**Consultation Response from KC Landscape**

<b>Application No:</b>	2025/93480
<b>Proposed Development:</b>	Erection of 28 dwellings with associated landscaping and external works
<b>Location:</b>	Land off Parkwood Road/Weavers Lane, Longwood, Huddersfield, HD3 4TT
<b>Applicant/Agent:</b>	ELG Planning
<b>Planning Officer</b>	Ellie Thornhill
<b>Date Responded:</b>	23.04.2026
<b>Responding Officer:</b>	Landscape
<b>Responding Ref:</b>	PP81

Proposed Shrubs

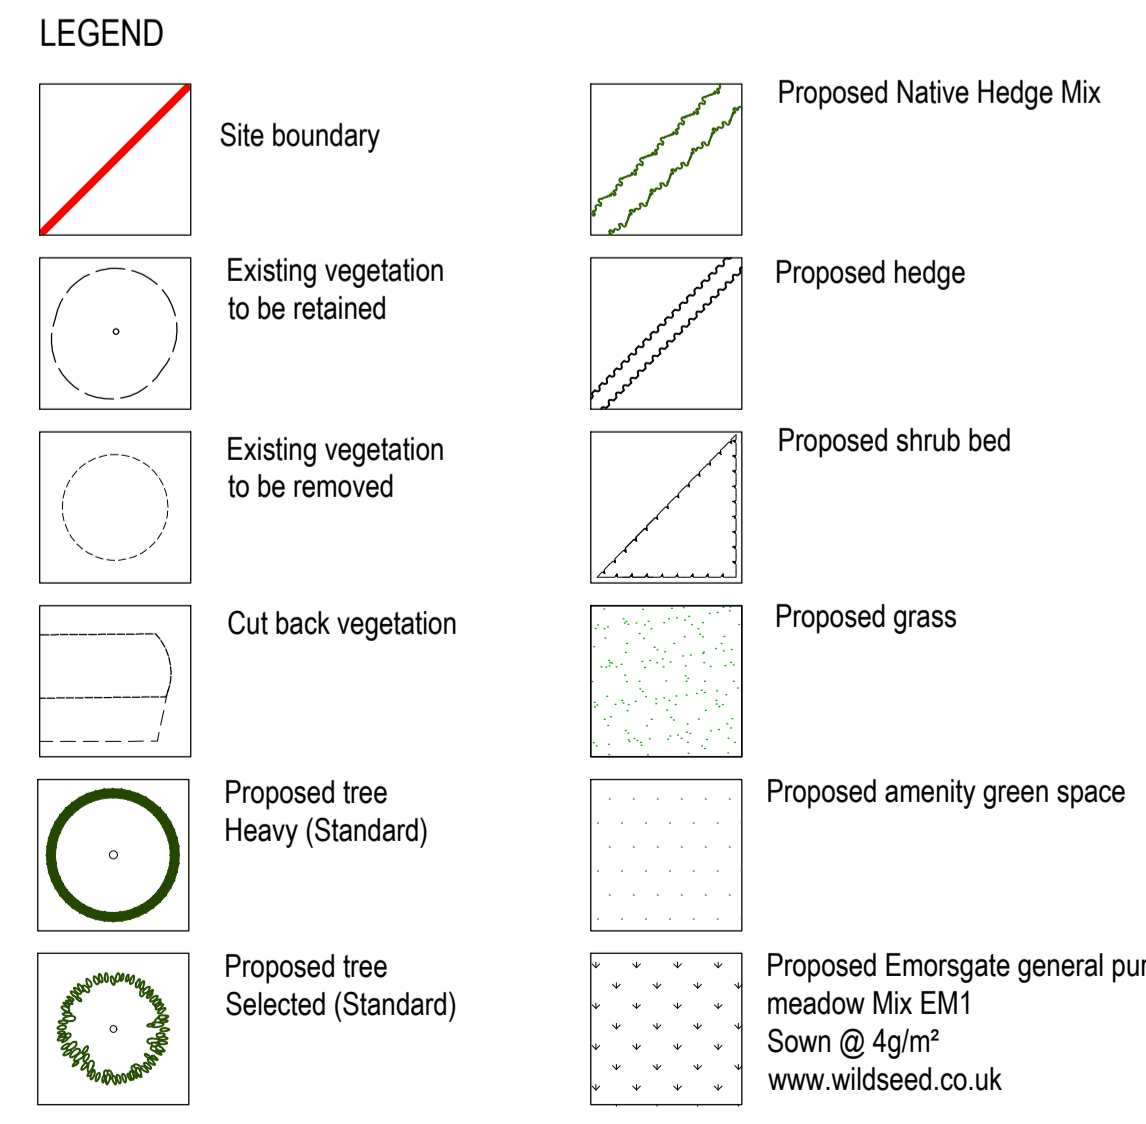
The proposed planting palette includes several taxa that appear on the NECR053 screened lists as Critical, Urgent or Moderate Risk, including species such as *Lonicera nitida*, *Pyracantha* spp., *Cornus alba* and *Berberis thunbergii*.

Species on Plan	NECR053 Listing	Risk Category
<i>Lonicera nitida</i>	Yes	Critical
<i>Pyracantha</i> (spp./cultivars)	Yes	Critical
<i>Berberis thunbergii</i>	Yes	Moderate Risk
<i>Cornus alba</i>	Yes	Urgent
<i>Viburnum davidii</i>	Genus only	Related to Urgent taxa

- Reconsiders the inclusion of NECR053-listed species where suitable lower-risk alternatives are available; or
- Provides justification for their use and confirms appropriate management measures to prevent escape or spread beyond the site.
